Site Plan Drawing_V2.pdf Markup Summary

VENETUCCI FARMS

A PORTION OF THE SW $\frac{1}{4}$ OF THE SW $\frac{1}{4}$ OF SECTION 11 AND A PORTION OF THE NW $\frac{1}{4}$ OF SECTION 14, EL PASO, COUNTY
 5202 HWY 85-87, 5210 HWY 85-87, 5304 HWY 85-87 & 5304 HWY 85
SPECIAL USE PERMIT - BUSINESS EVENT CENTER

1 ADA/VAN ACCESSIBLE PARKING SIGNS

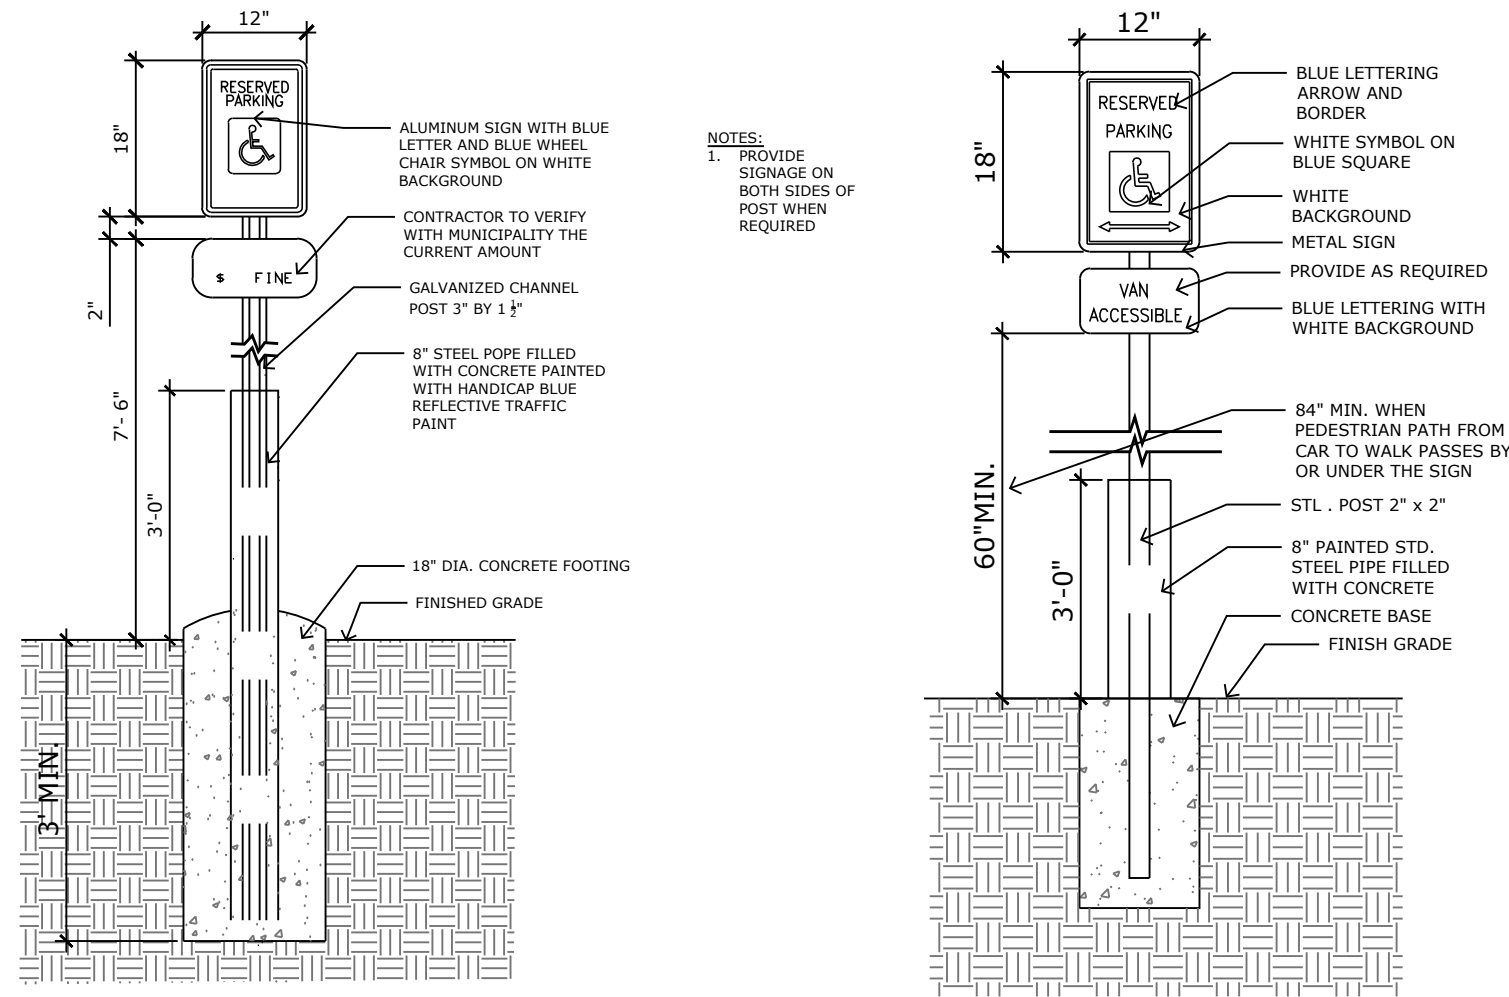
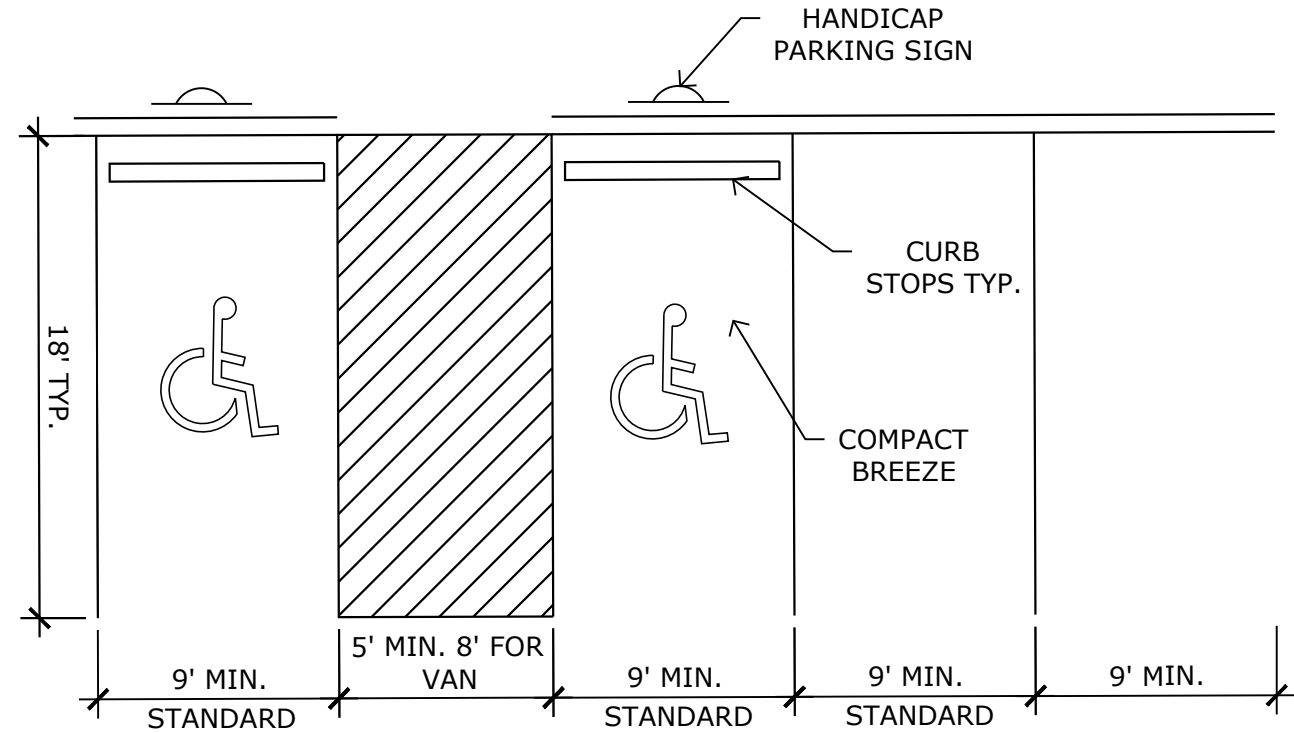
Include percent of open space, landscaping and lot coverage on plan.

Only 3 ADA parking spaces shown on plan. Please revise.

On the cover sheet, 4 ADA parking spaces were required and provided. Here on the plan only shows 3 ADA parking space. Please clarify and revise accordingly.

3

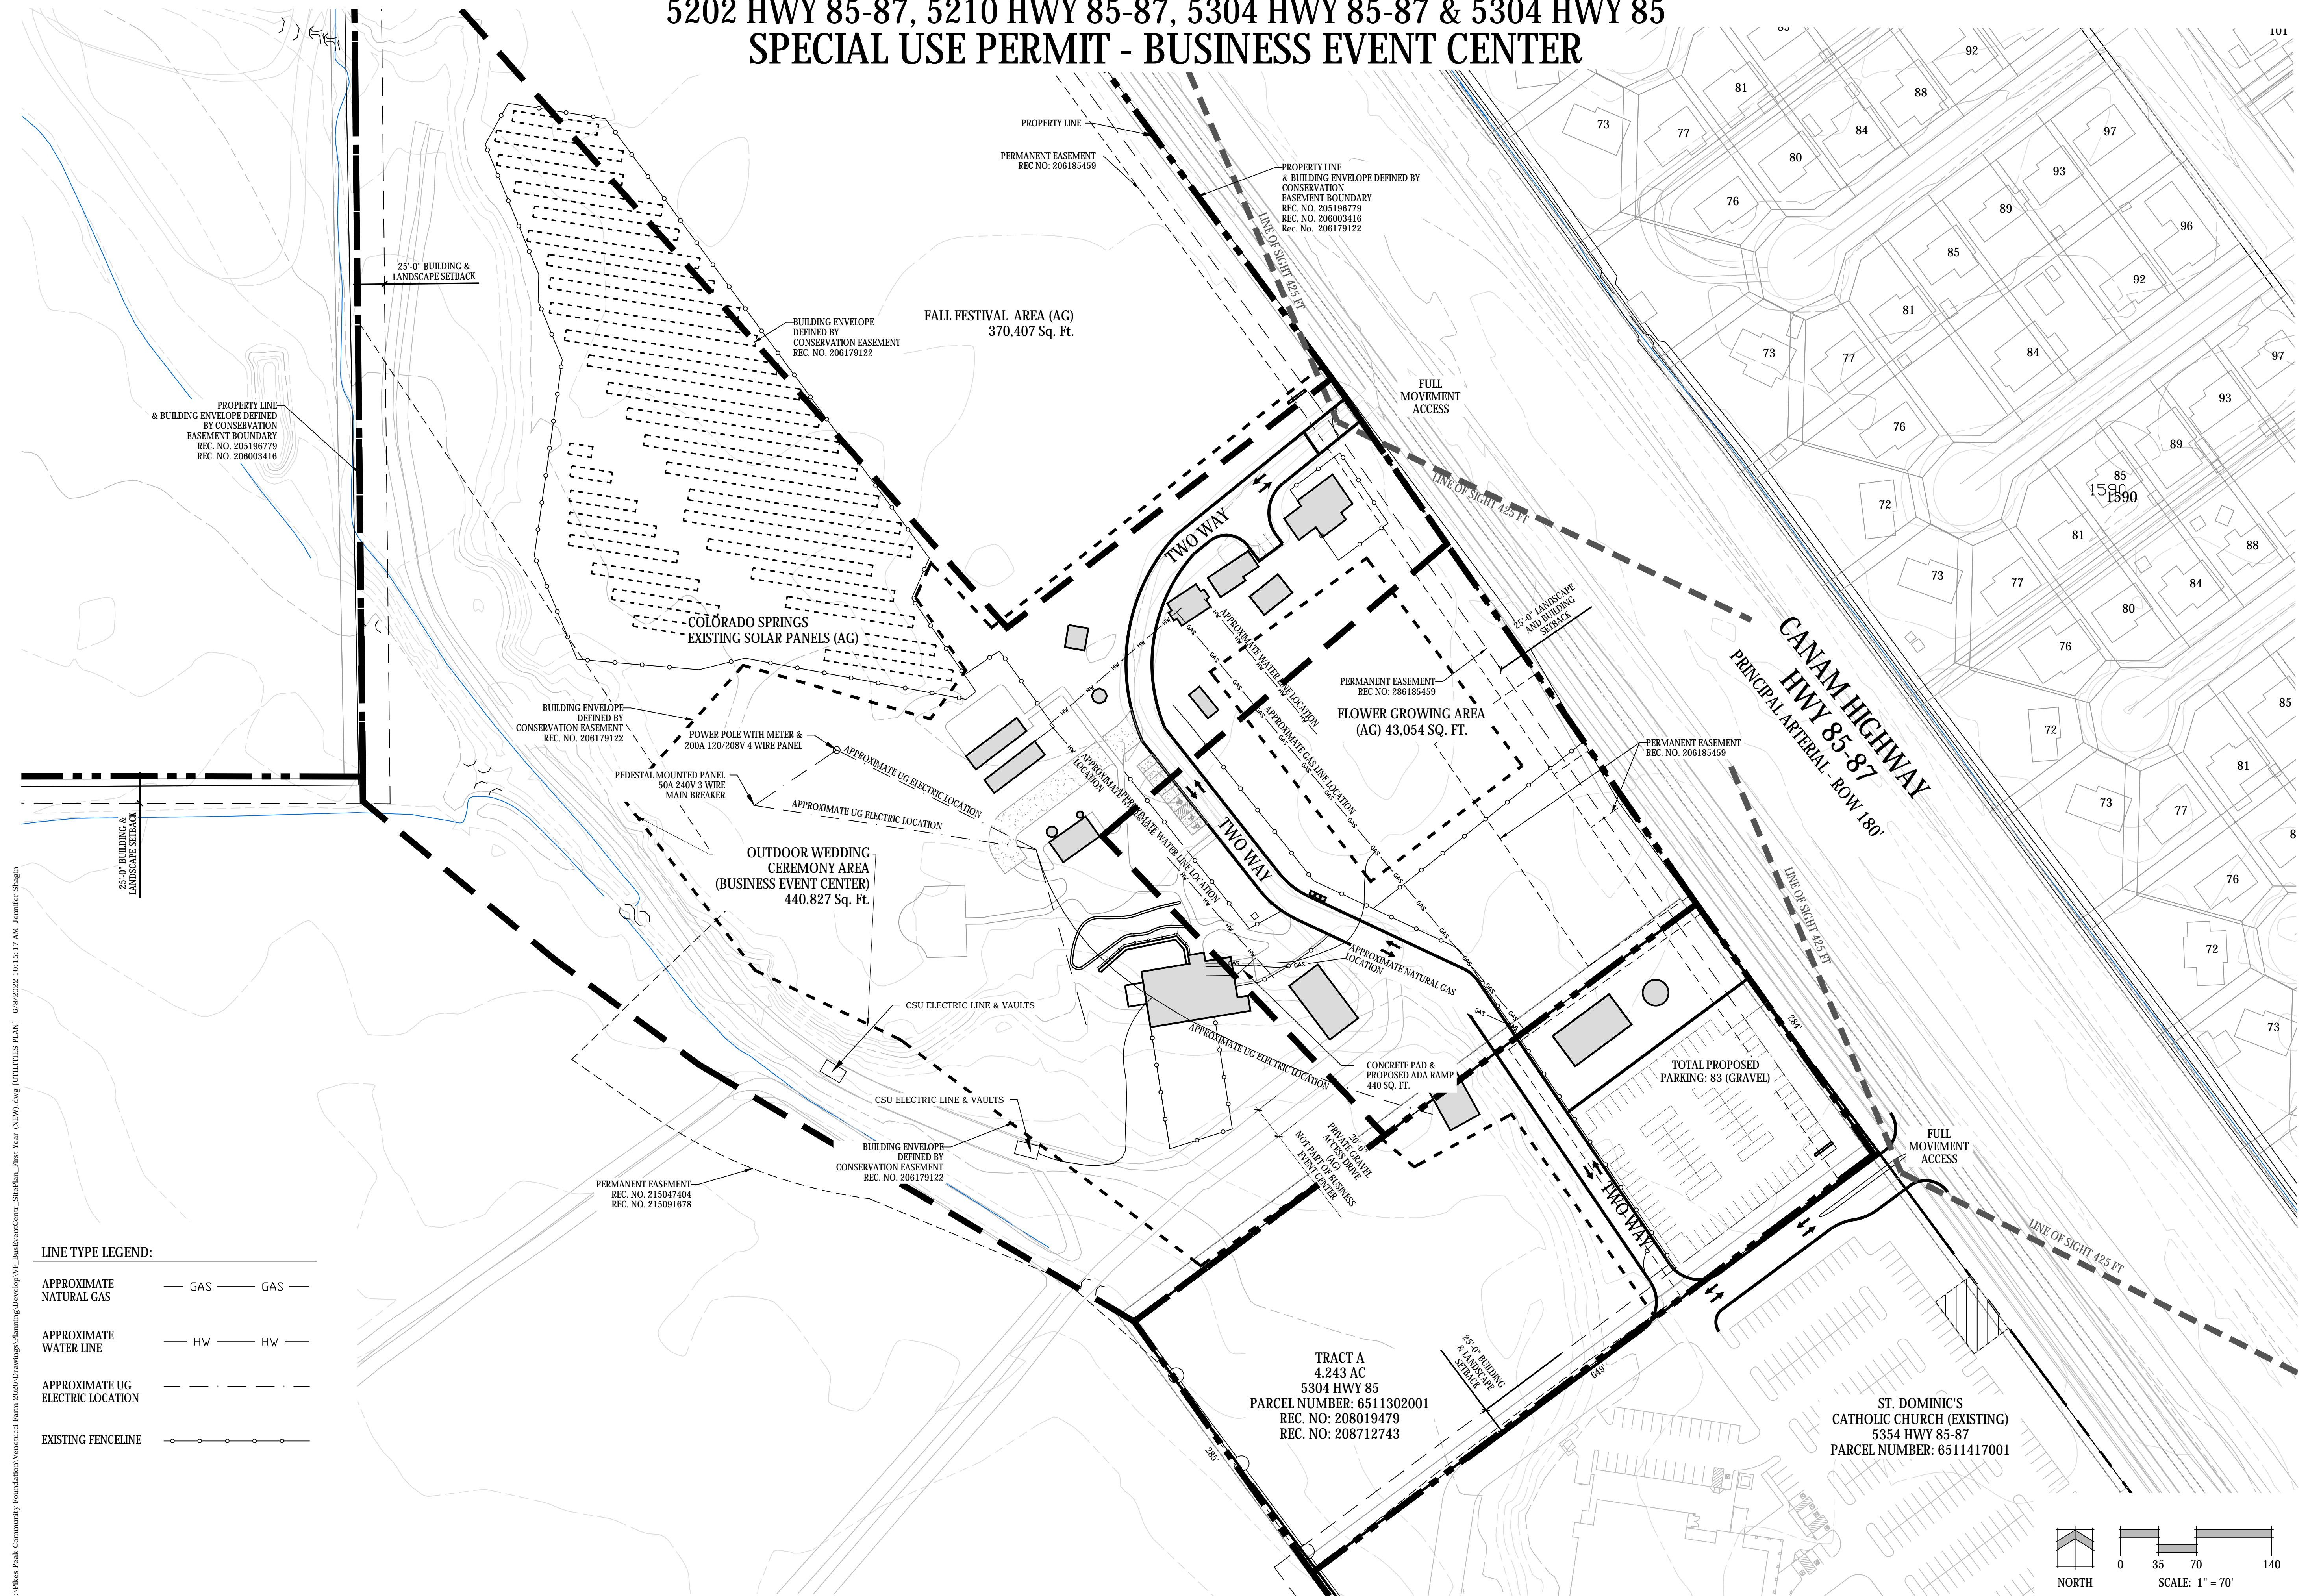
Show location, height and intensity of all outdoor illumination on plan.

7 OF 9

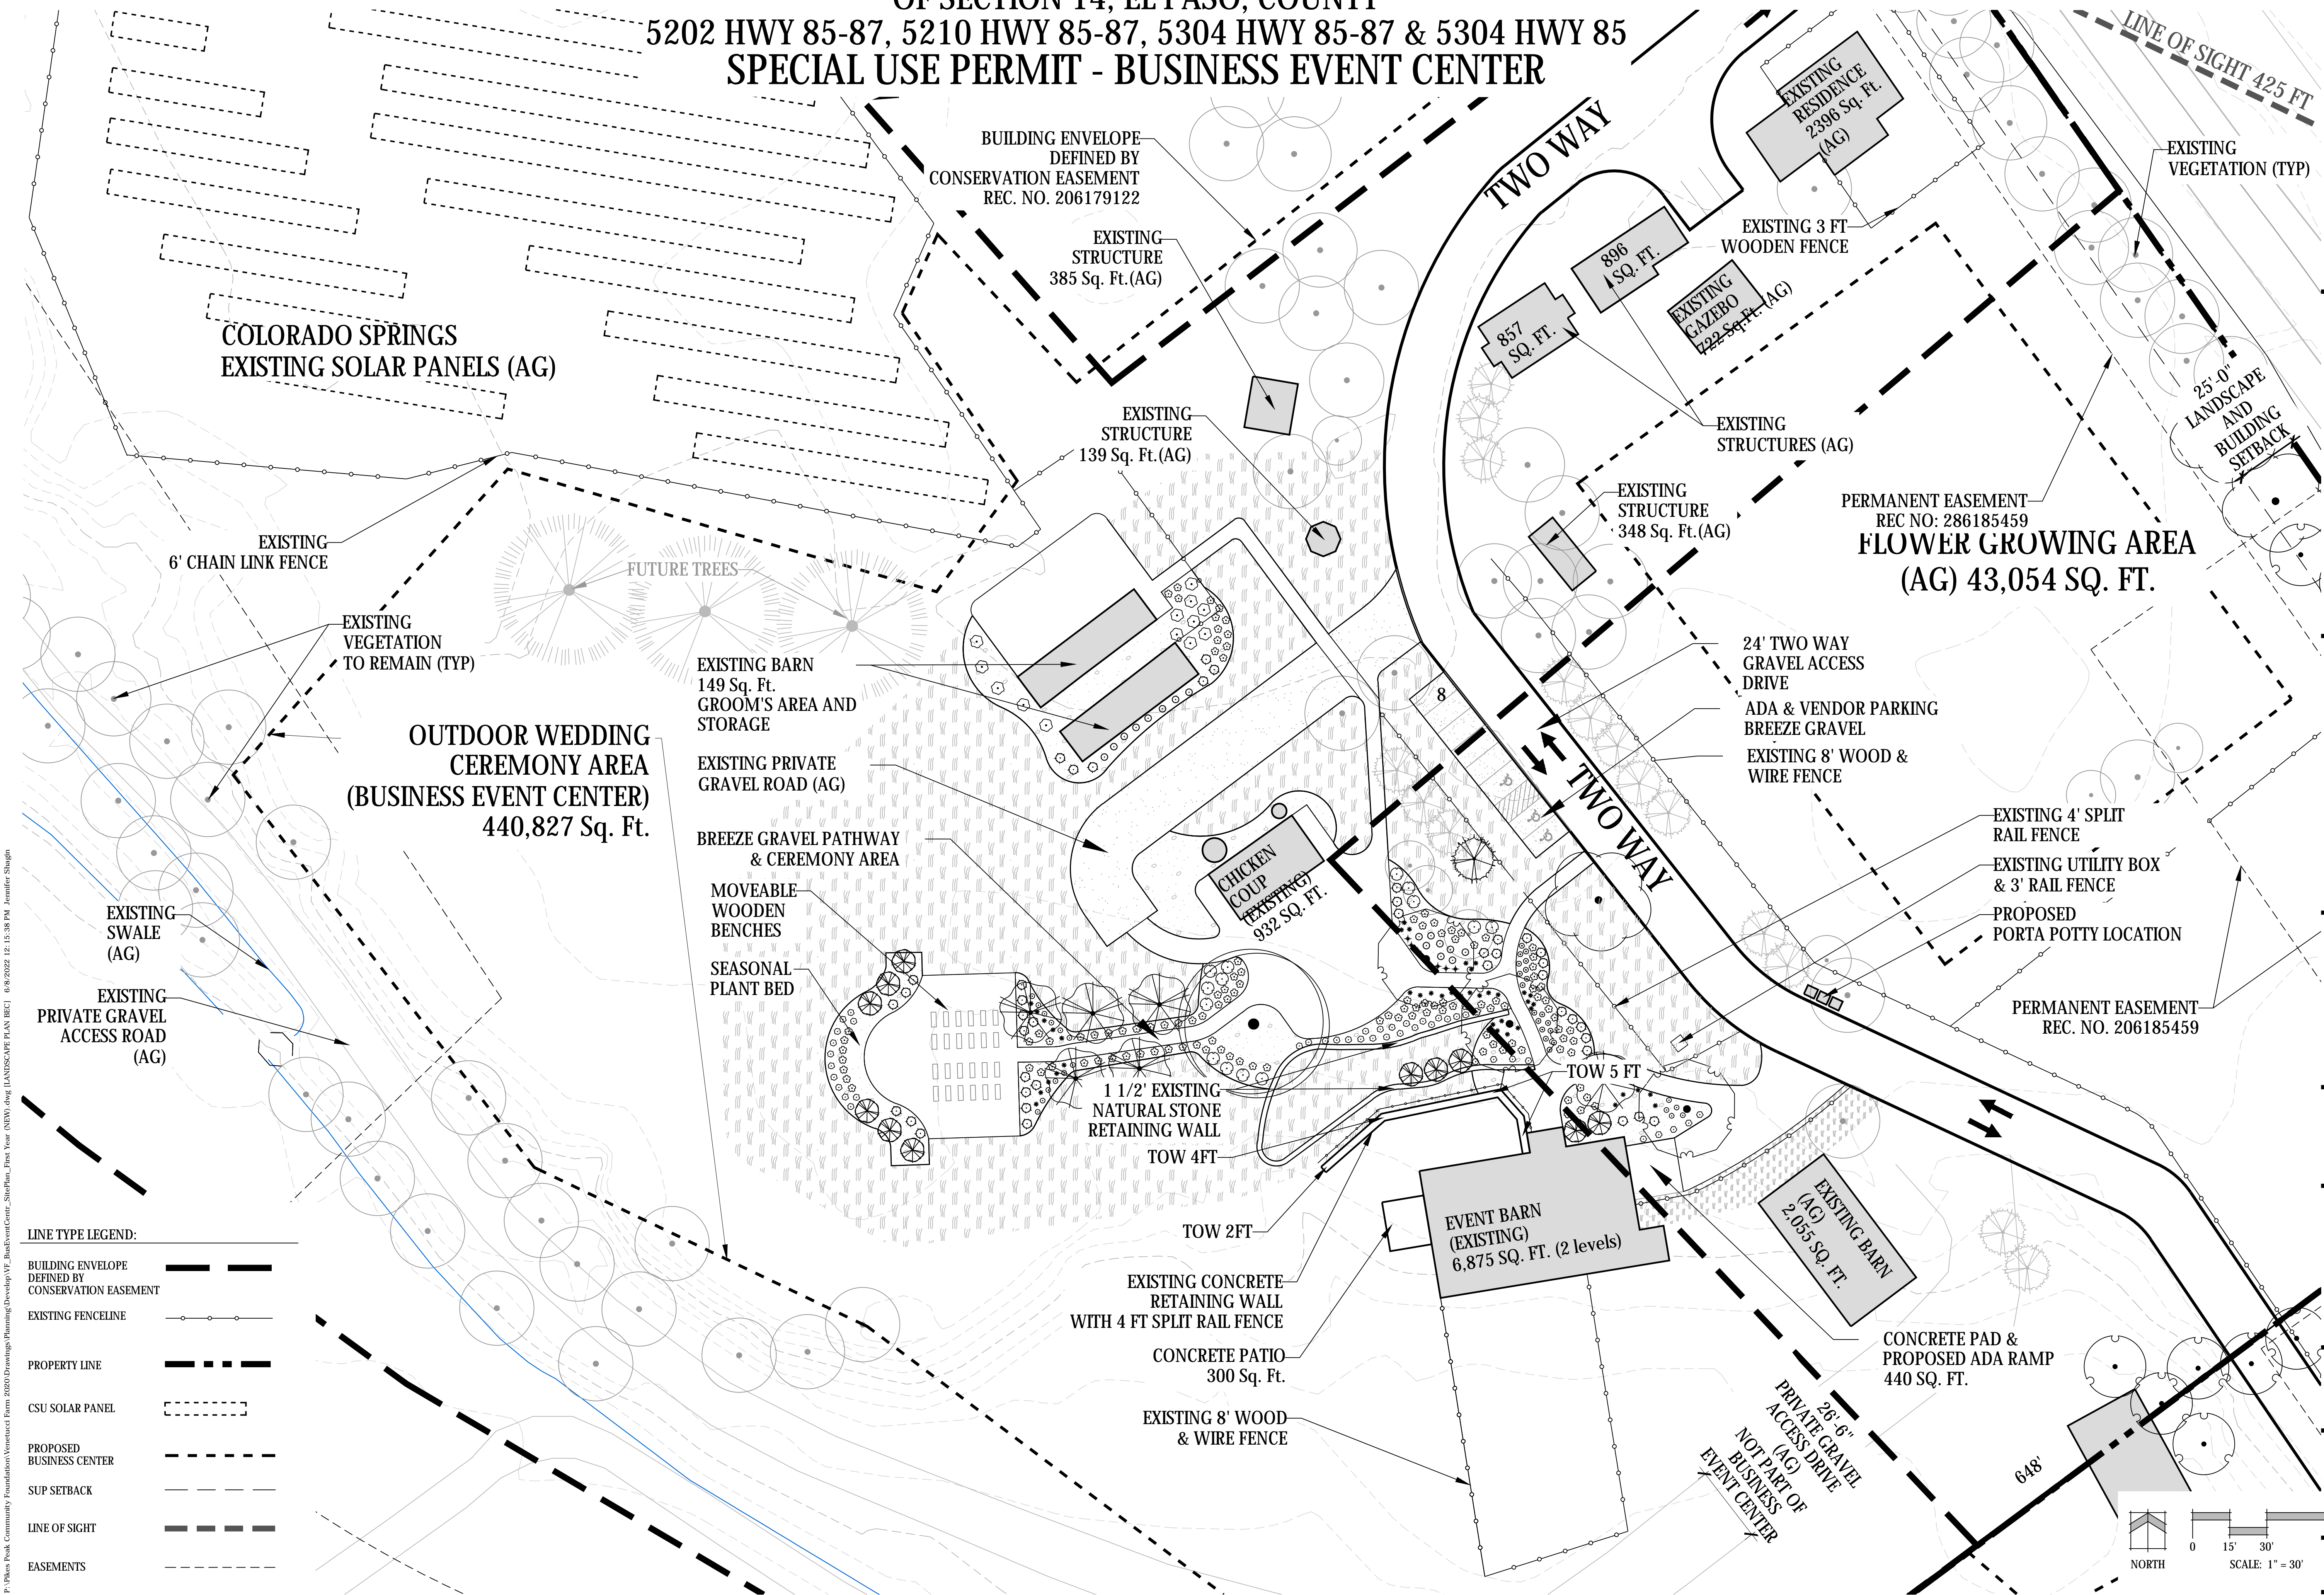
Call out the floodplain and drainage facility on plan.
